**Date: June 13, 2013**

**Project Name: Marriott Courtyard**

**Plan Reviewer: SFC Engineering Partnership, Inc.**

Plan Type: Construction Set - Architectural

A0.1 SHEET

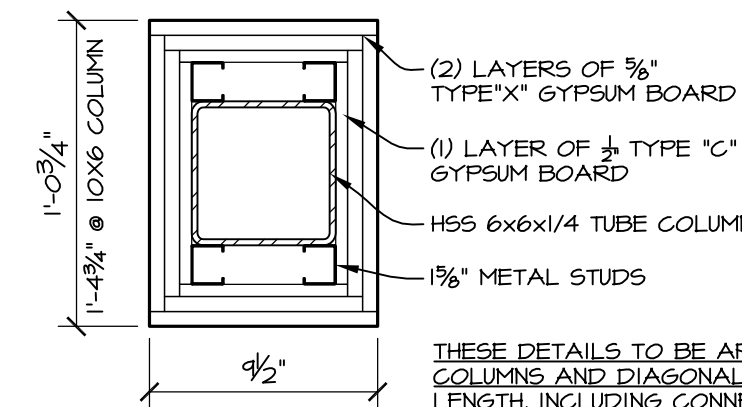
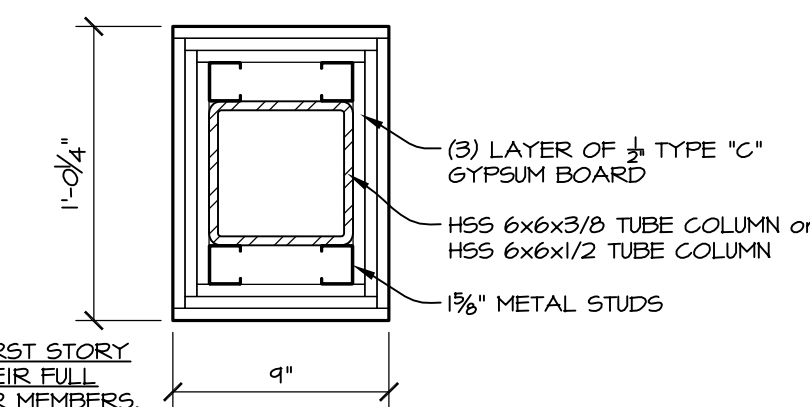
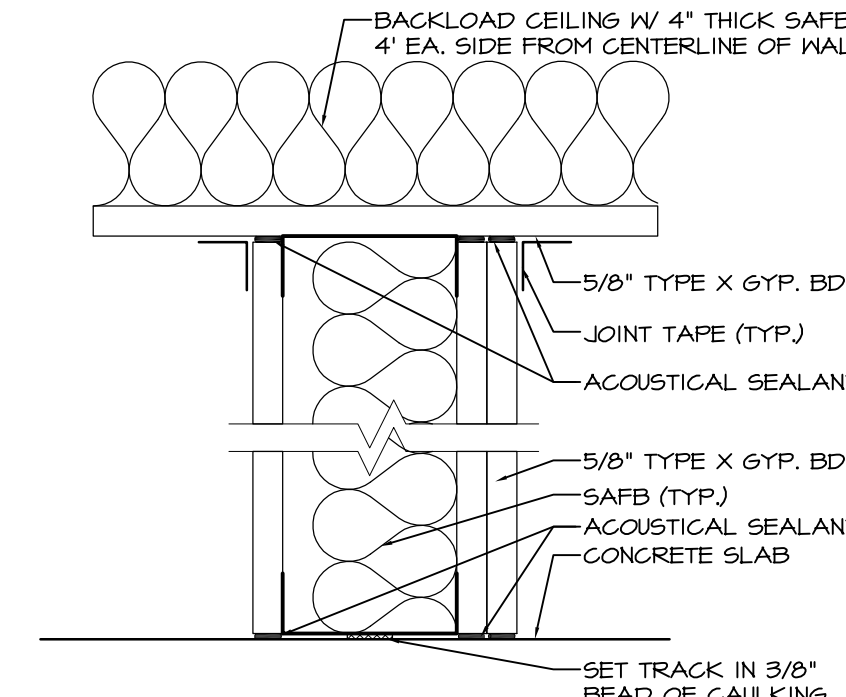
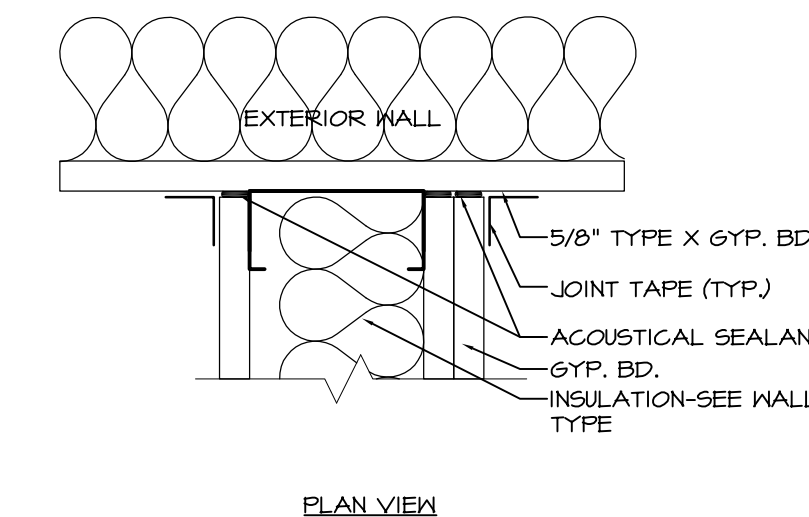
1. A0.1: The code summary must be updated to include *City of Portland: Code of Ordinances*.
2. A0.1: A meeting room is located on the building's second story. Since its occupant load exceeds 50 people, requirements for Assembly Use Groups (A-3) shall be taken into consideration for floors 2 through 6. Per §6.1.14.1.3 in NFPA 101-2009, Assembly Occupancies are not permitted to be incidental to other Use Groups.

HOTEL GUEST ROOM DOOR/FRAME TYPES

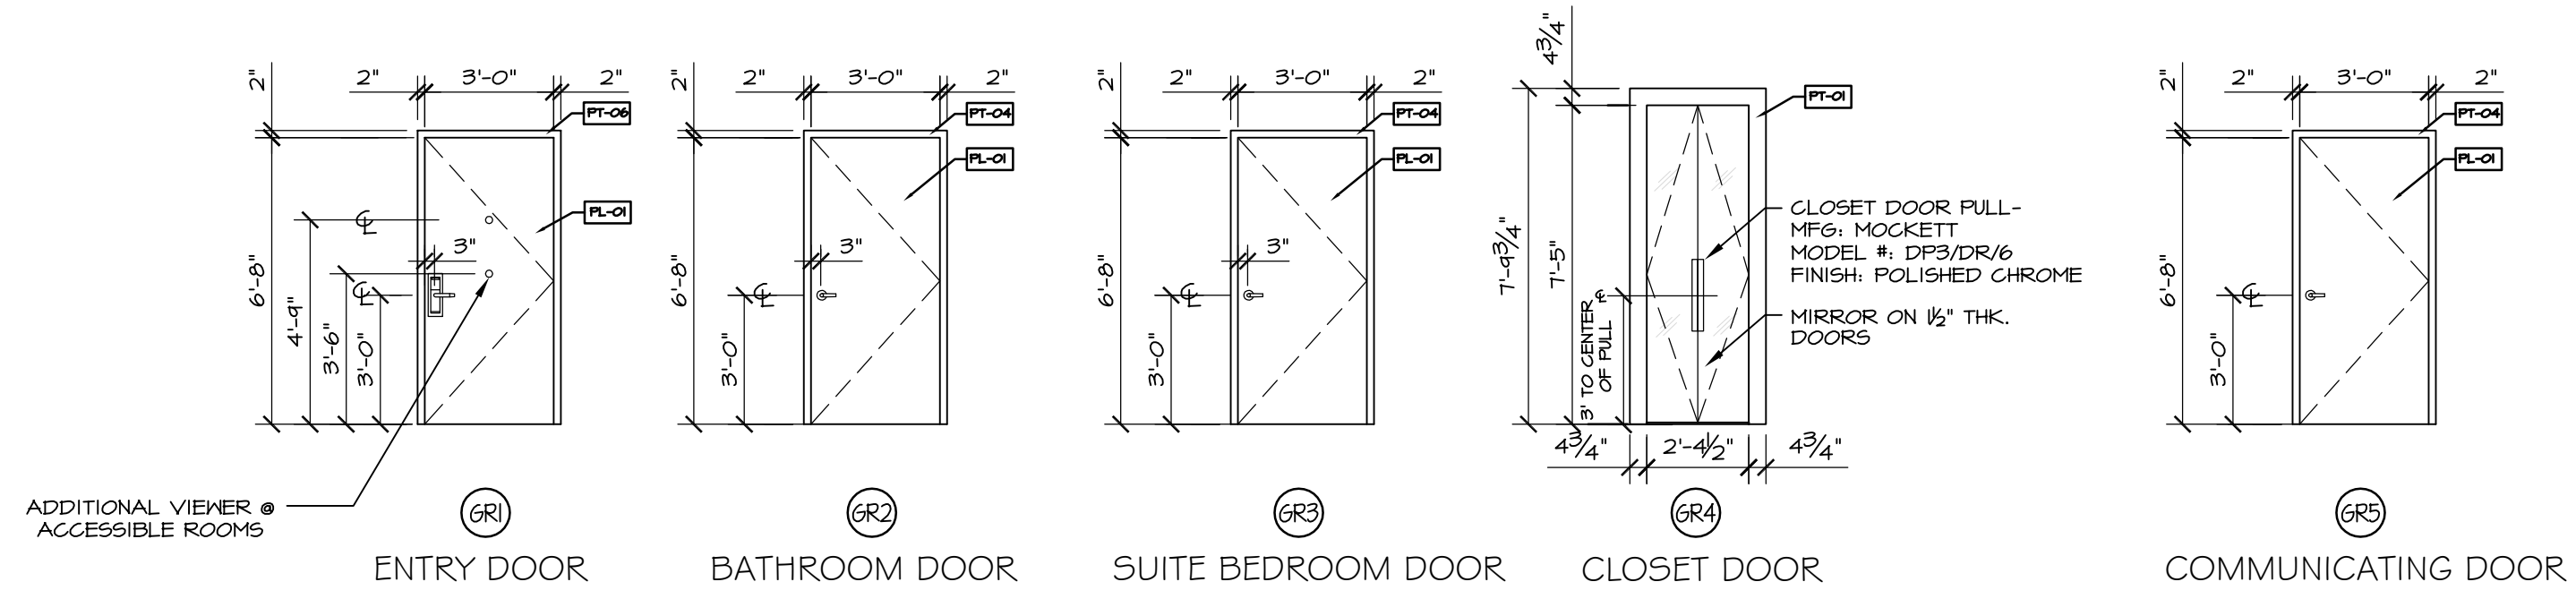
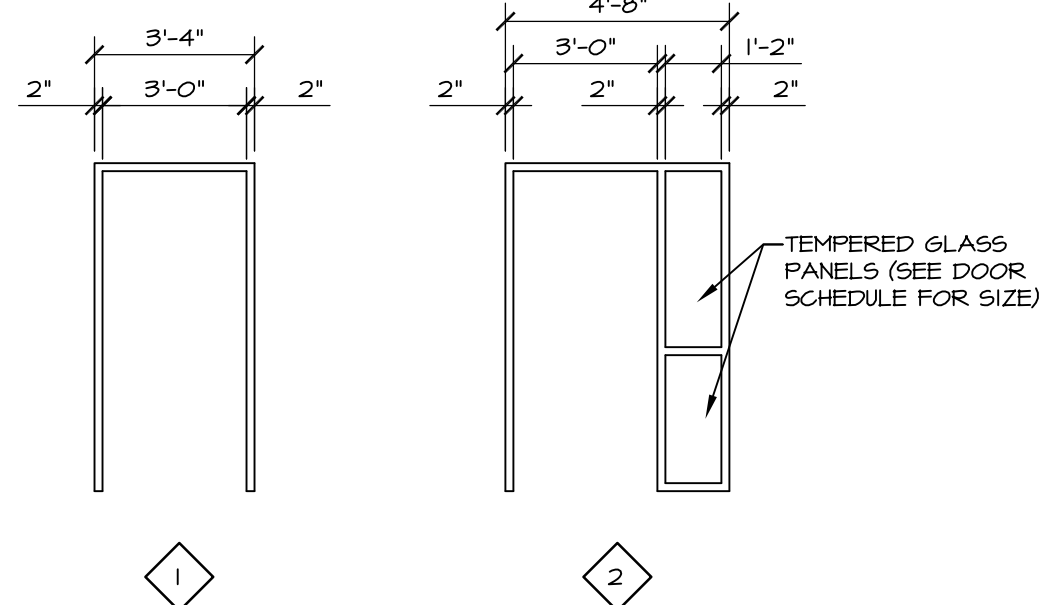
4. A21: According to §28.3.6.2 and §30.3.6.2 in NFPA 101-2009, hotel and apartment doors shall: (1) possess at least a 20 minute fire resistance rating, (2) resist the passage of smoke, and (3) be equipped with self-closing devices. Please verify that all entry doors comply with applicable codes.

DATE: 05-09-13  
SCALE: SEE PLAN  
DRAWN BY: KPH  
SHEET: A0.2

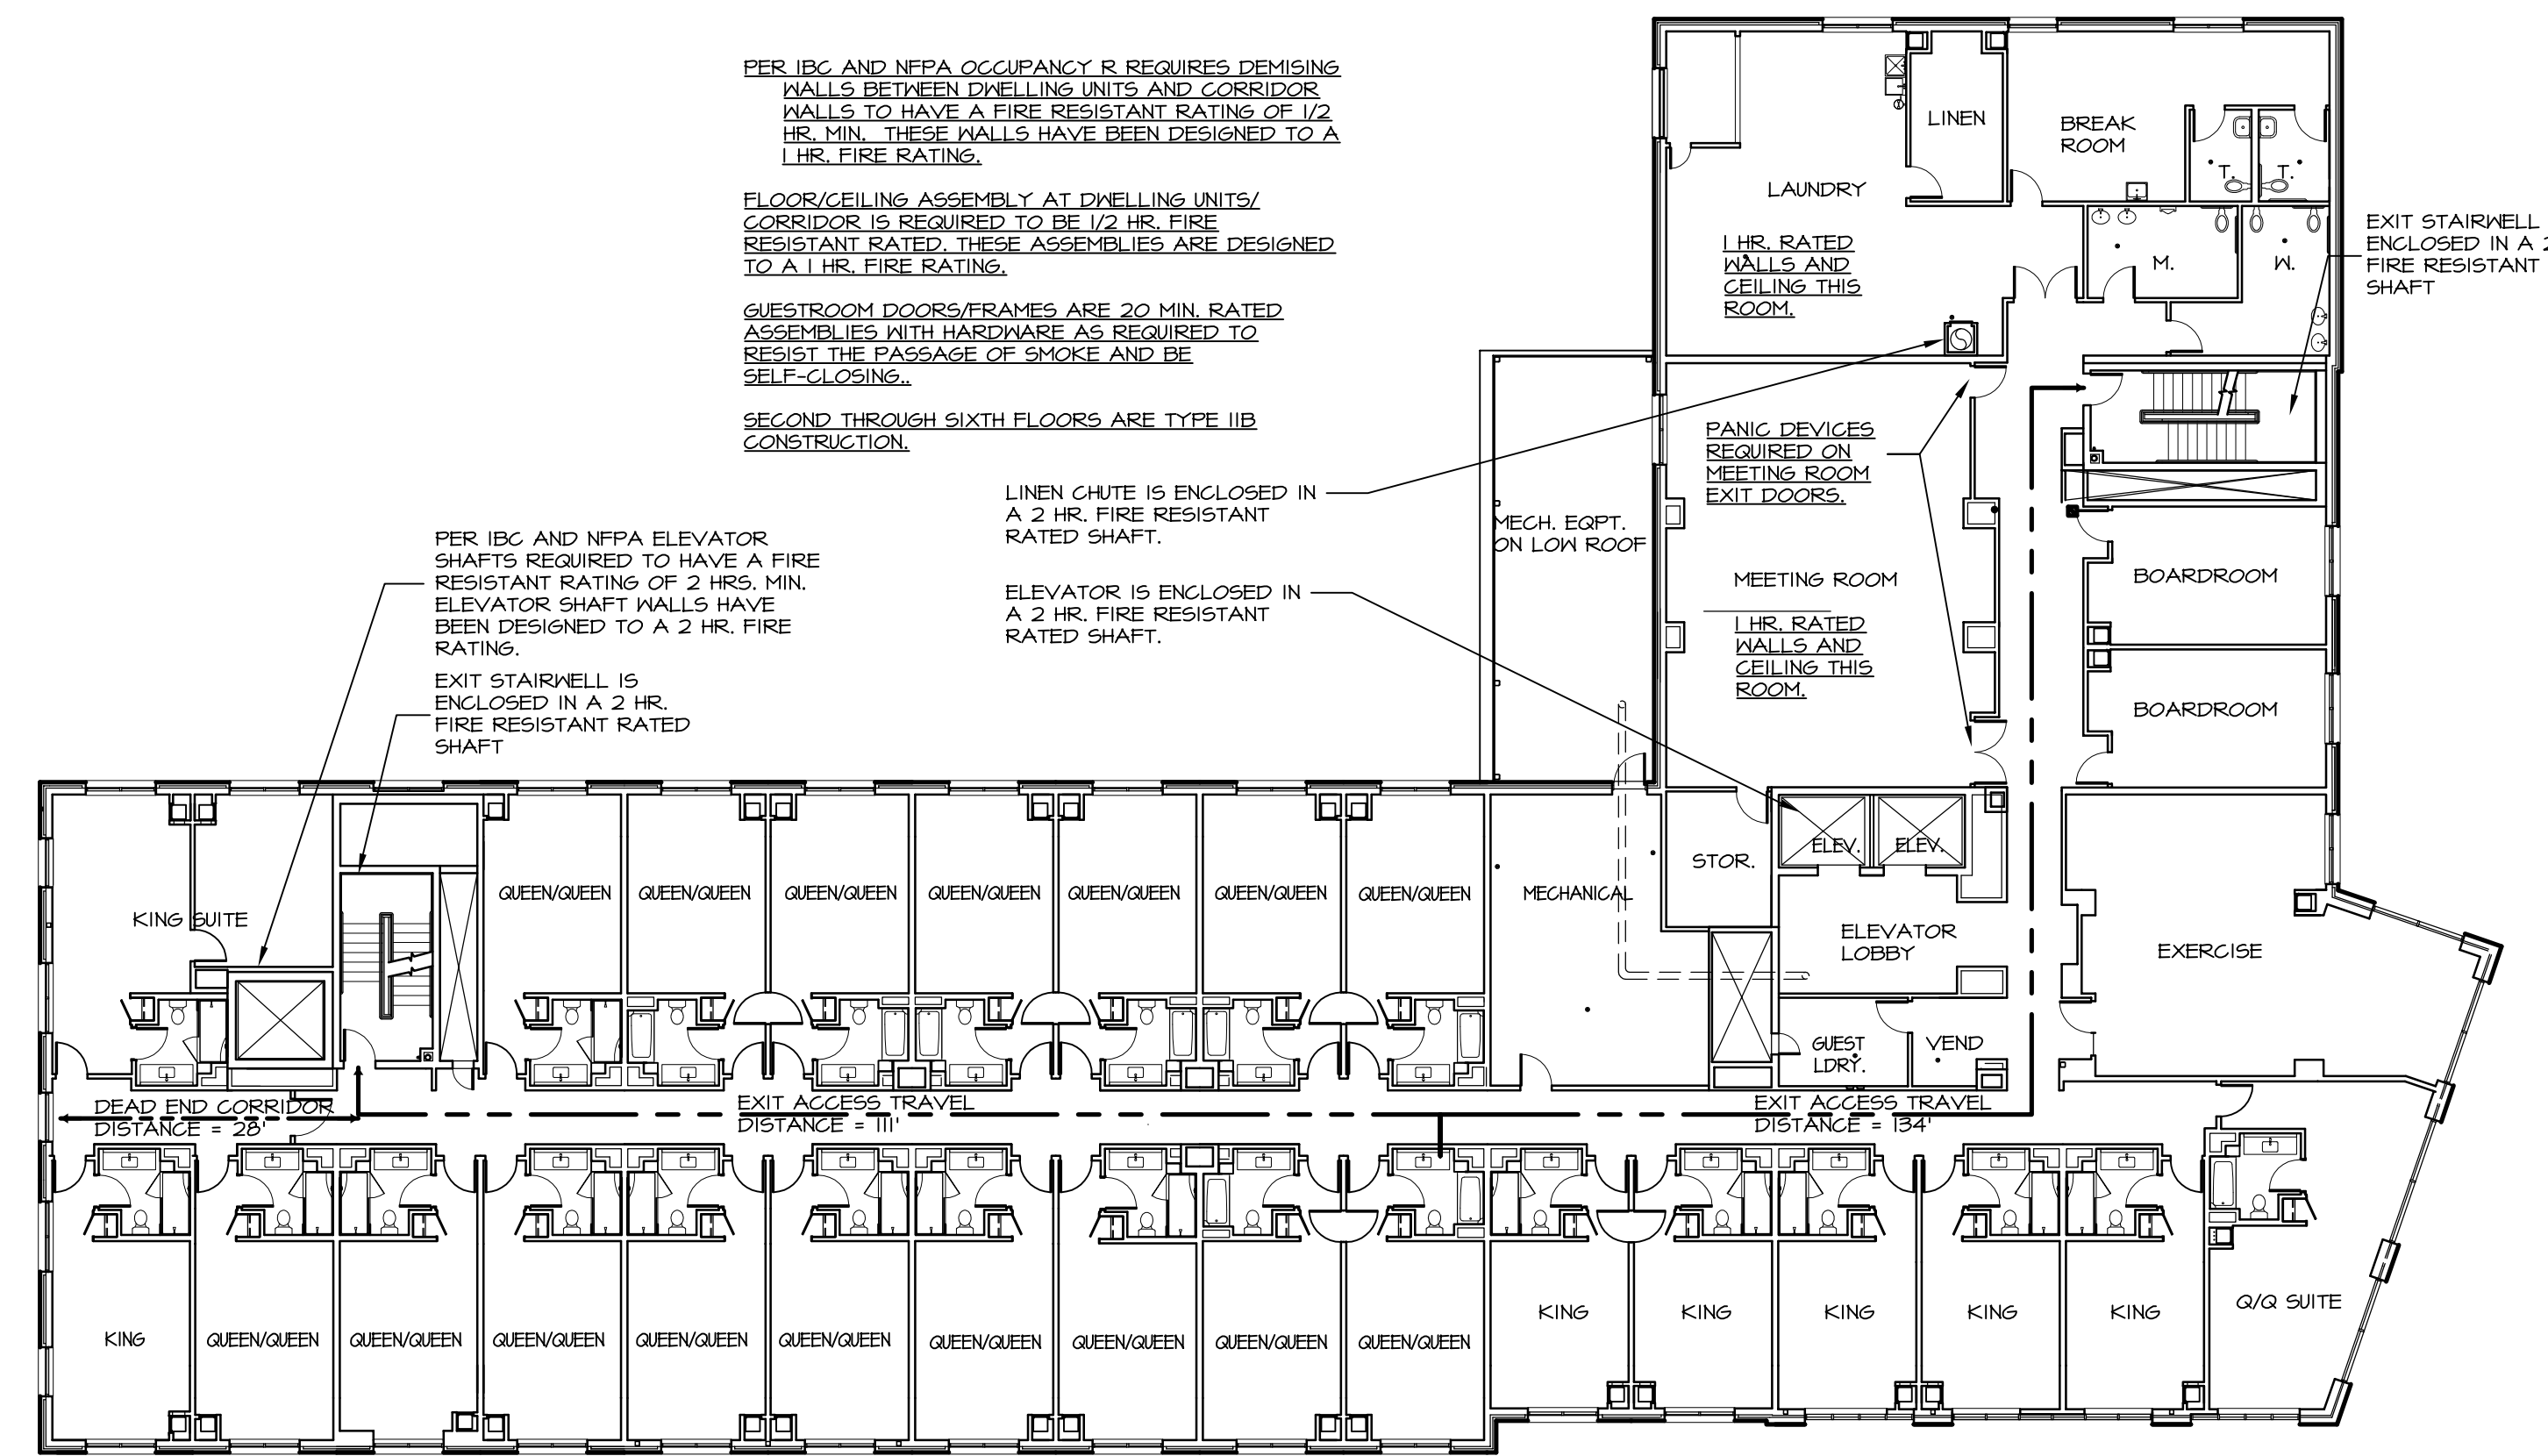
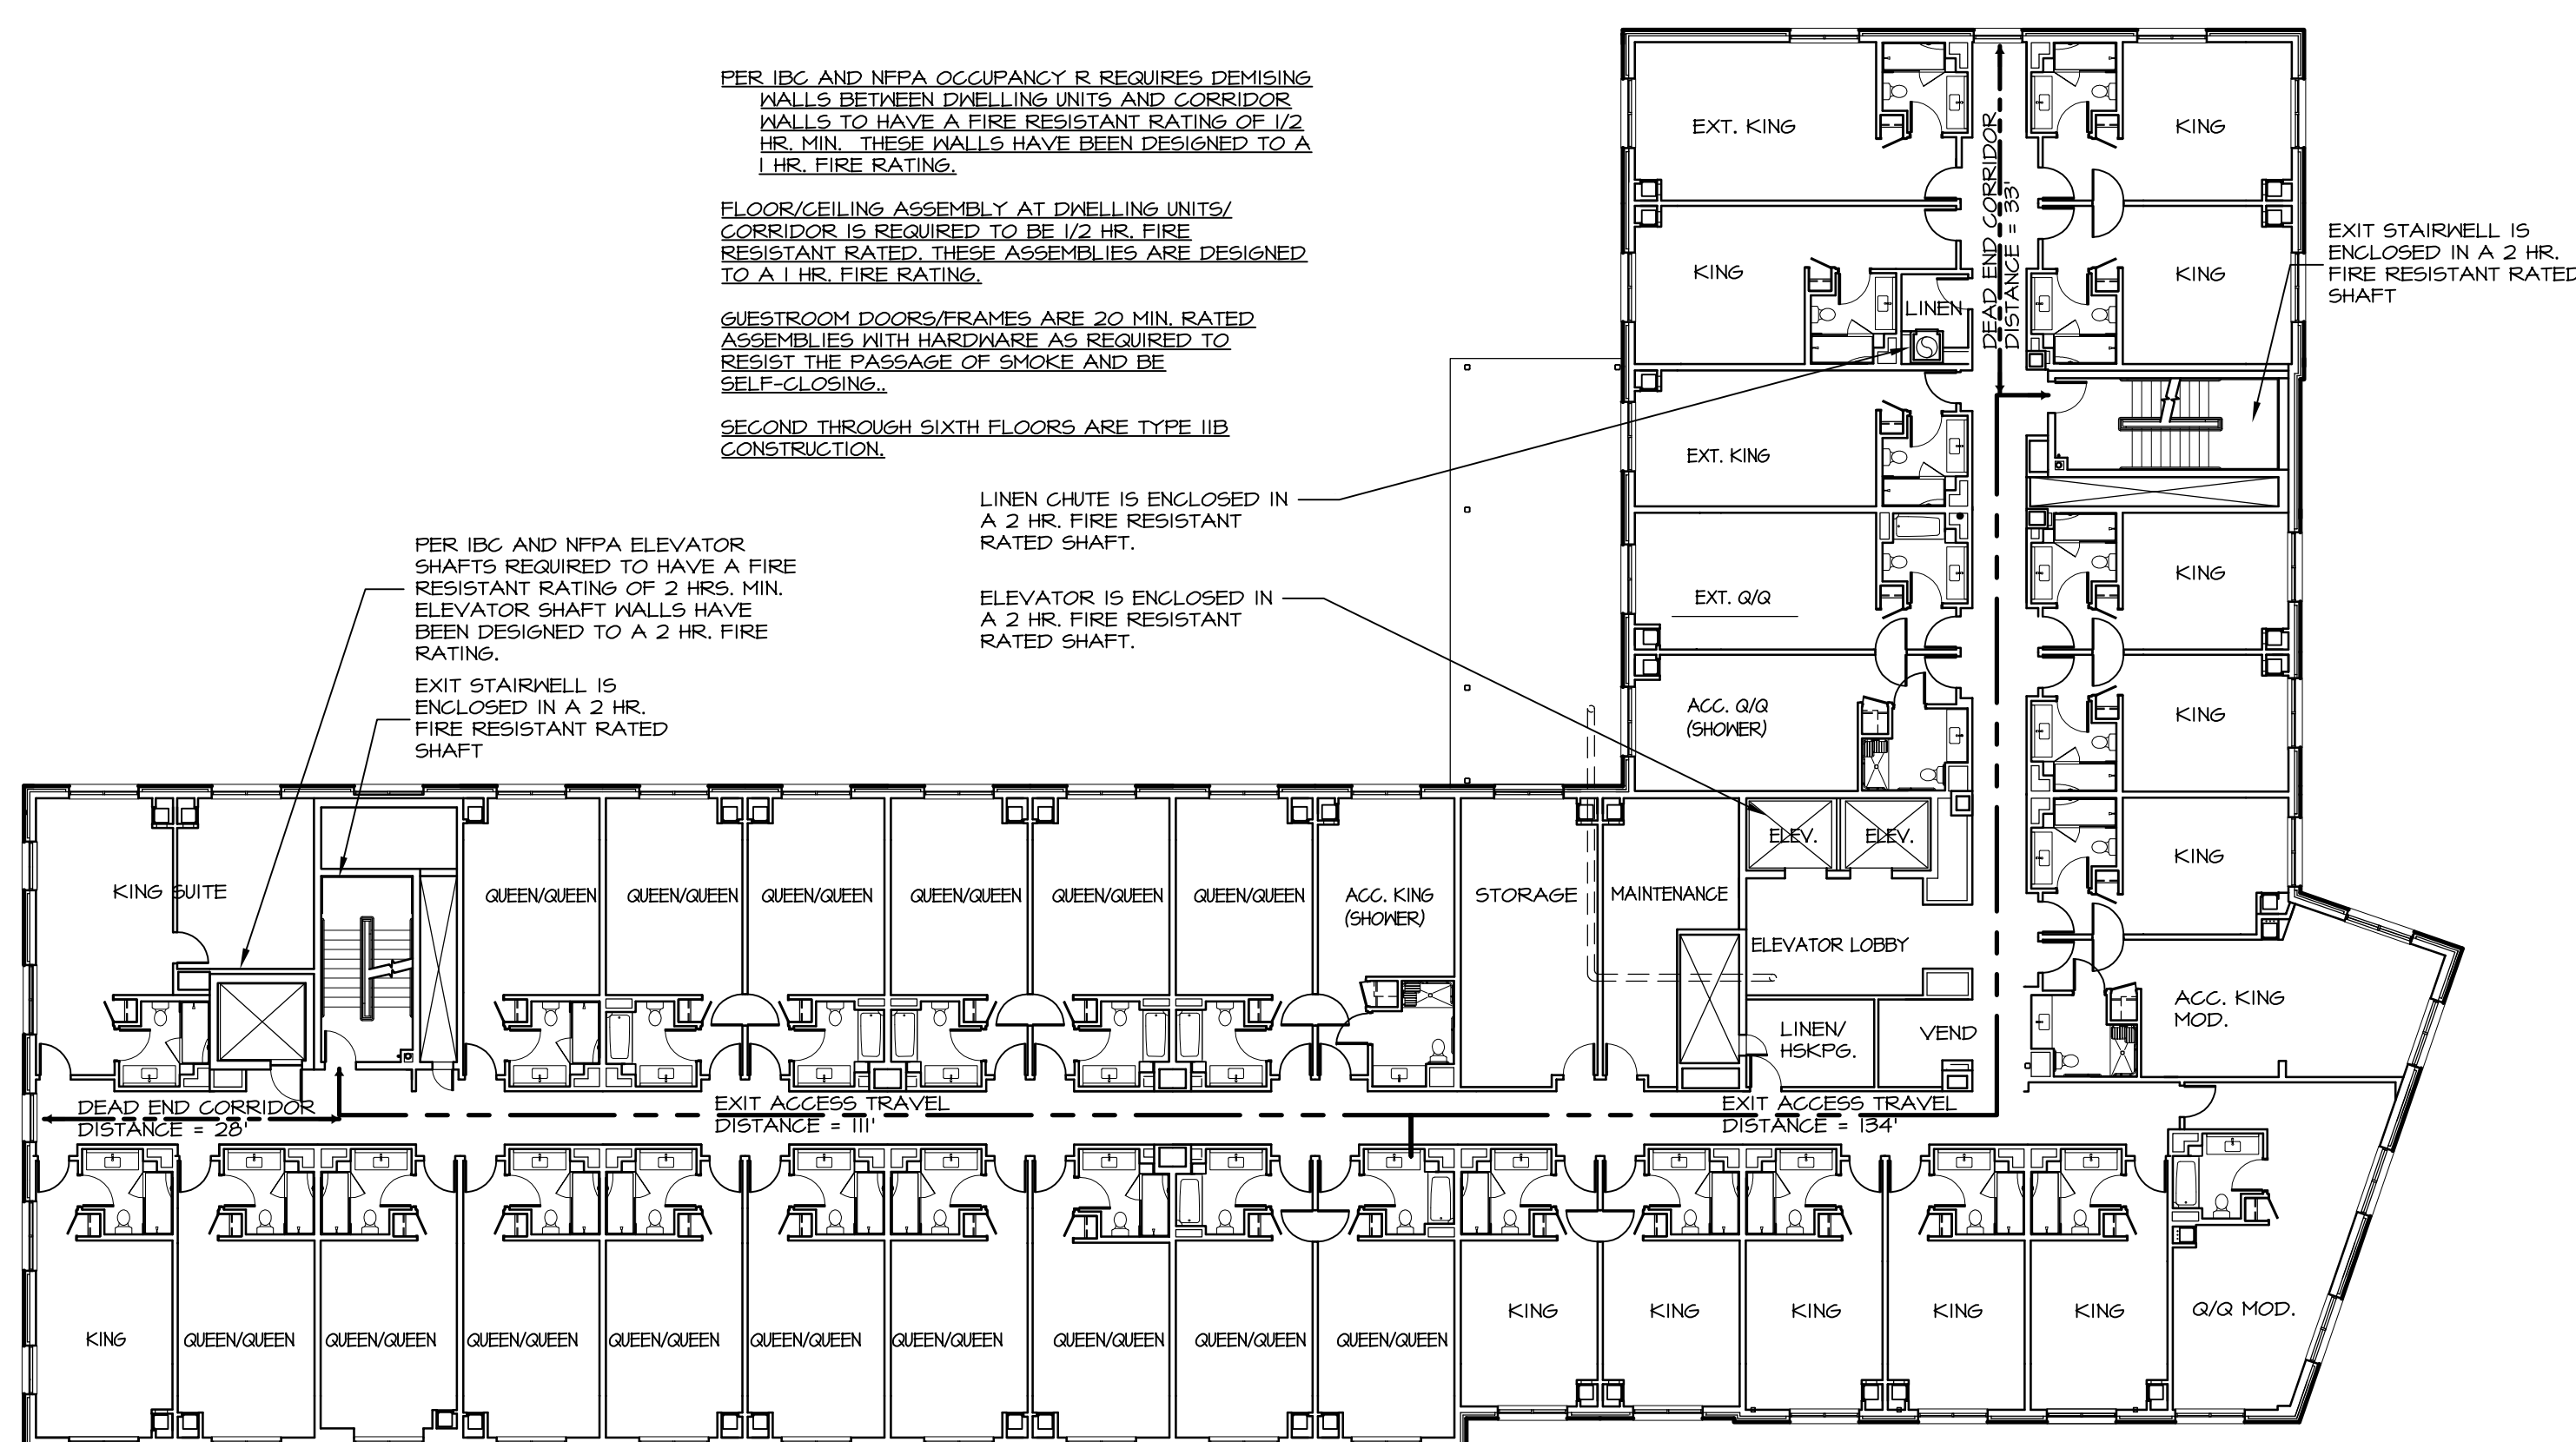
3. A0.2-3: Areas mixed with Assembly Use Groups cannot contain dead end distances in excess of 20'. At both ends of each corridor on floors 2 through 5, dead end distances exceed 20'.
